Martin Nugent
01254 828060
D3/12/0751

Drafted 26 September 2012

**Planning Application, Ribble Valley District
3/12/0751 Methodist Chapel, Church Lane, West Bradford**

Site plan

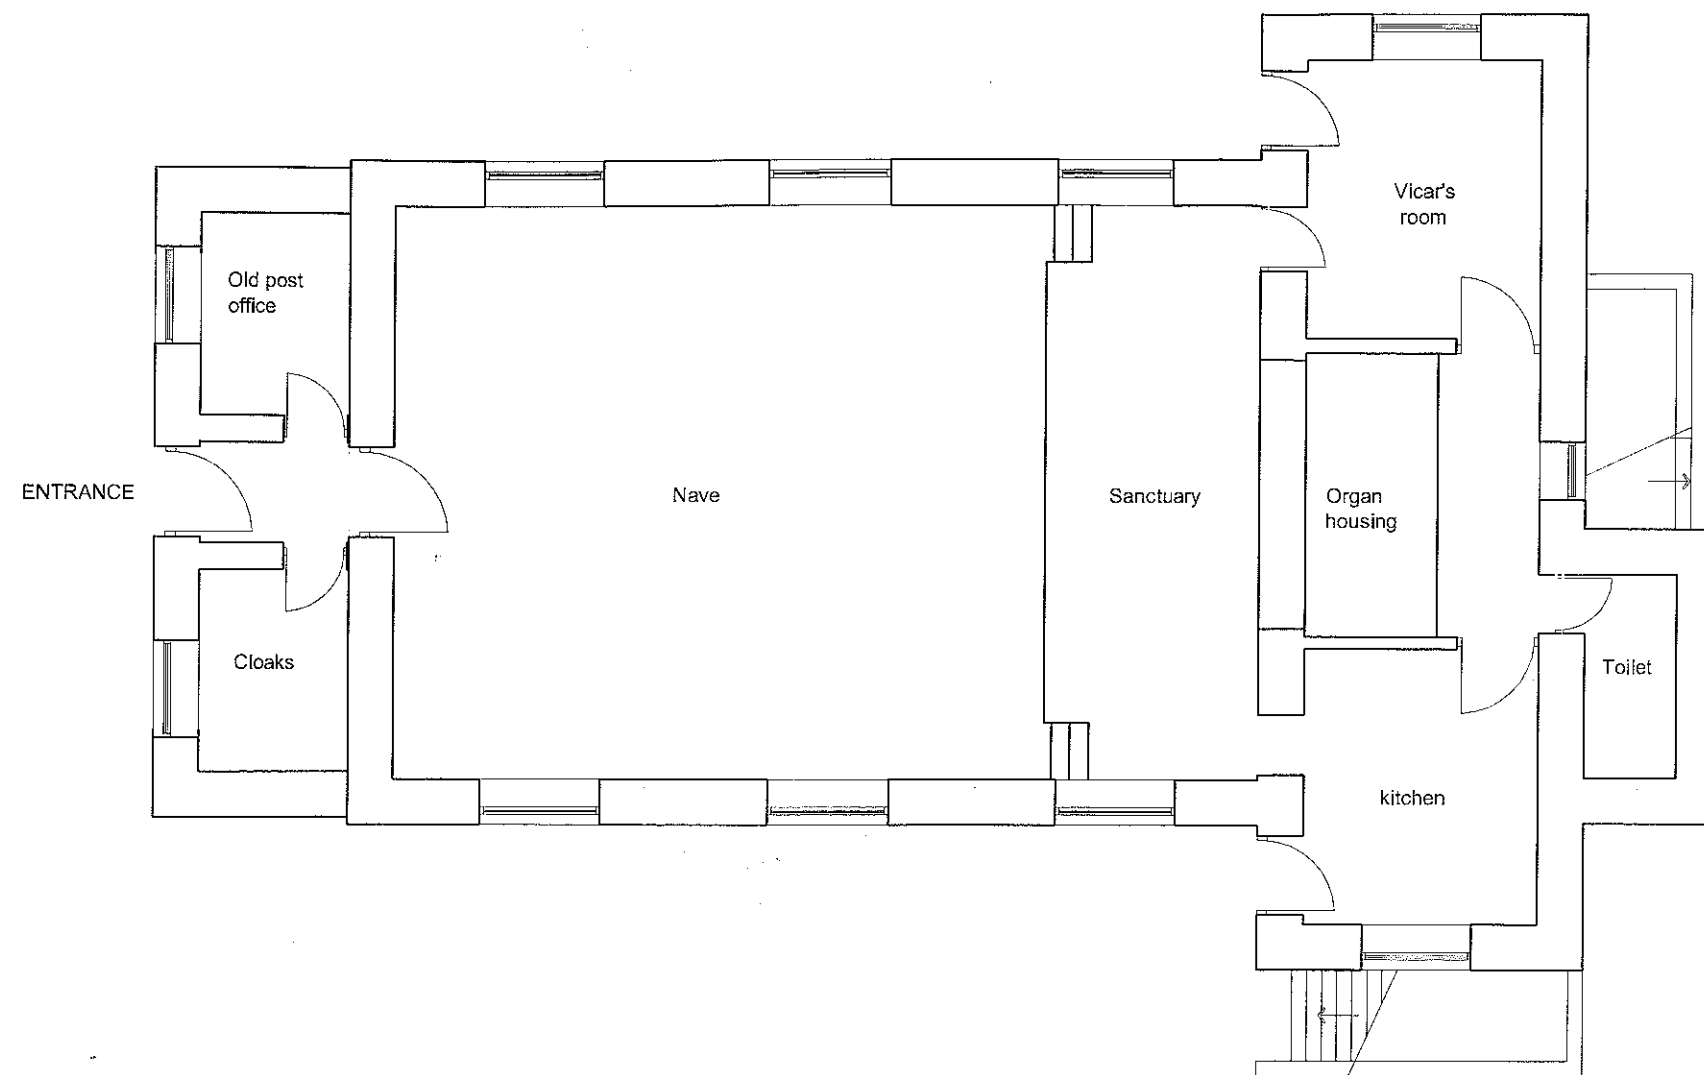
However, it is not clear from the plans and elevations provided if there is to be a gate across the driveway, leading from Church Lane. If a gate is to be included it must be set back a minimum of 5.0m from the back of carriageway and the gateposts must be set at 45degrees to the carriageway.

In addition, there is no footway along the frontage with Church Lane and it is not clear if the boundary wall is less than 1.0m in height to either side of the driveway. If the line of the boundary wall was to be pulled back a short distance, there exists an opportunity to provide a short footway link along the church frontage to provide improved pedestrian access to the existing bus stop and protection for an exposed lighting column.

Given that there will be engineering work required to achieve the requested widening of the access to secure a new driveway, the additional works required would not be extensive. Further to these comments, I have attached a rudimentary layout.

The layout for the driveway access must be designed to comply with LCC recommendations, as detailed below.

A The kerbing at the vehicular crossing shall be reinstated in accordance with the Lancashire County Council Specification for Construction of Estate Roads, concurrent with the formation of the improved access. This is to provide the necessary access and to maintain the proper construction of the highway.
